Our Ref: BR/56/26/DOC

Town & Country Planning Act 1990 (as amended)
Town and Country Planning (Development Management Procedure) (England) Order 2015
Approval of details reserved by condition under BR/5/25/PL relating to condition 5- Biodiversity
Enhancement Layout.
St Julianas Convent Marian Way Bognor Regis PO21 1PA

Arun District Council have decided to **APPROVE details reserved by this condition**

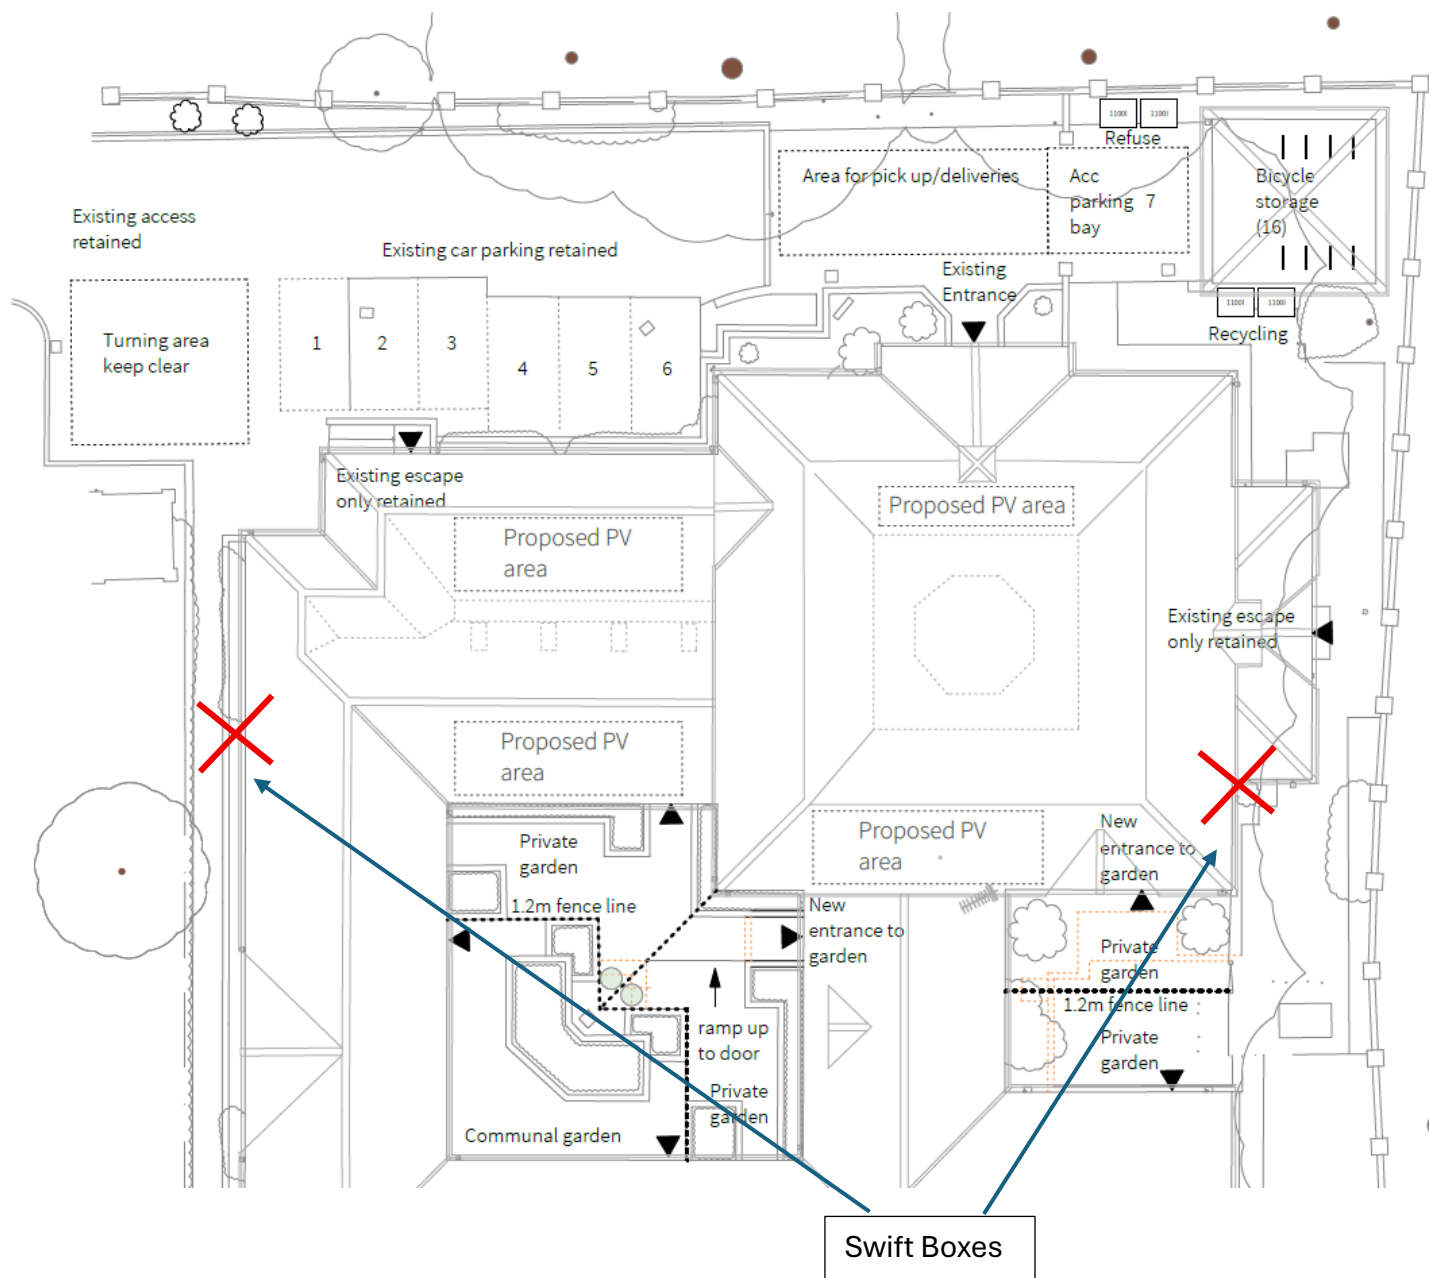
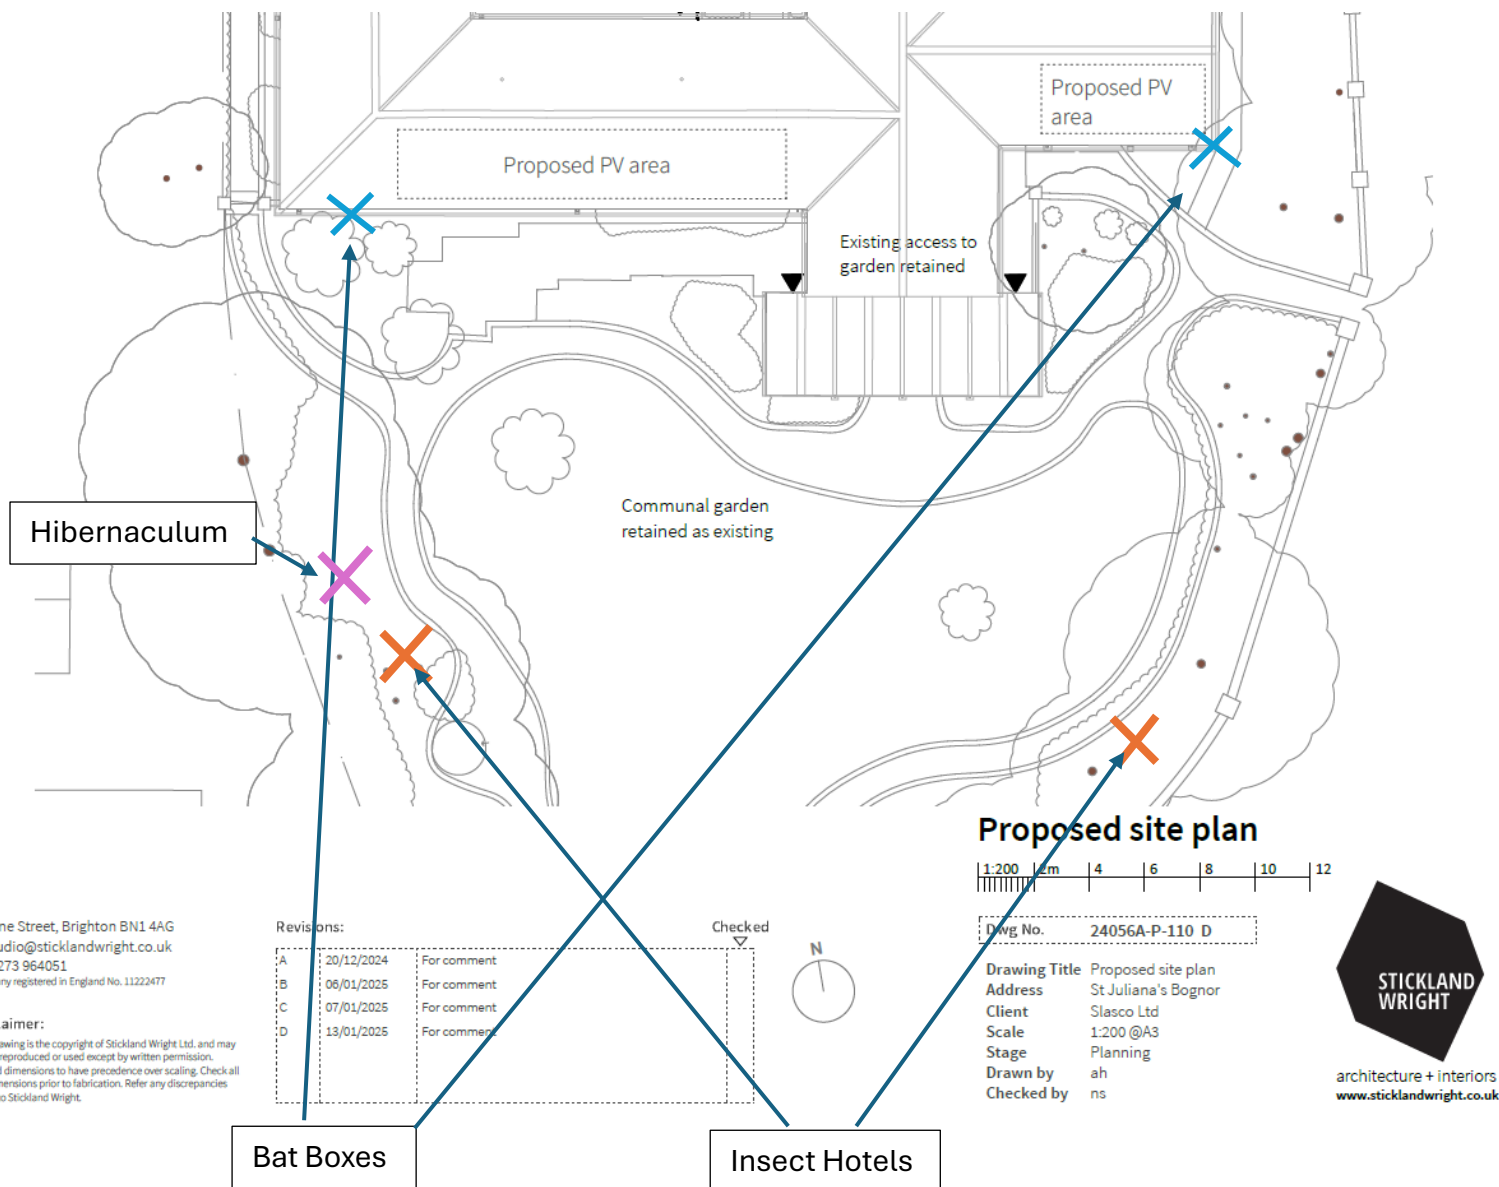
2 no. swift bricks, 2 no. bat boxes/tubes, 2 no. insect hotels and 1 no. hibernaculum have been provided and their location can be found on the approved dwgs. 'Approved Site Plan 1 of 2' and 'Approved Site Plan 2 of 2' dated 8 June 2026 and prepared by Strickland Wright.

The number of swift and bat boxes differs from the wording of the condition, which required three of each. This amendment was agreed in writing by an ADC Planning Officer in an email dated 1 April 2026 and is therefore acceptable.

The enhancement measures shall be installed in accordance with the approved details prior to the first occupation of any part of the development, and all features shall thereafter be retained in that manner.
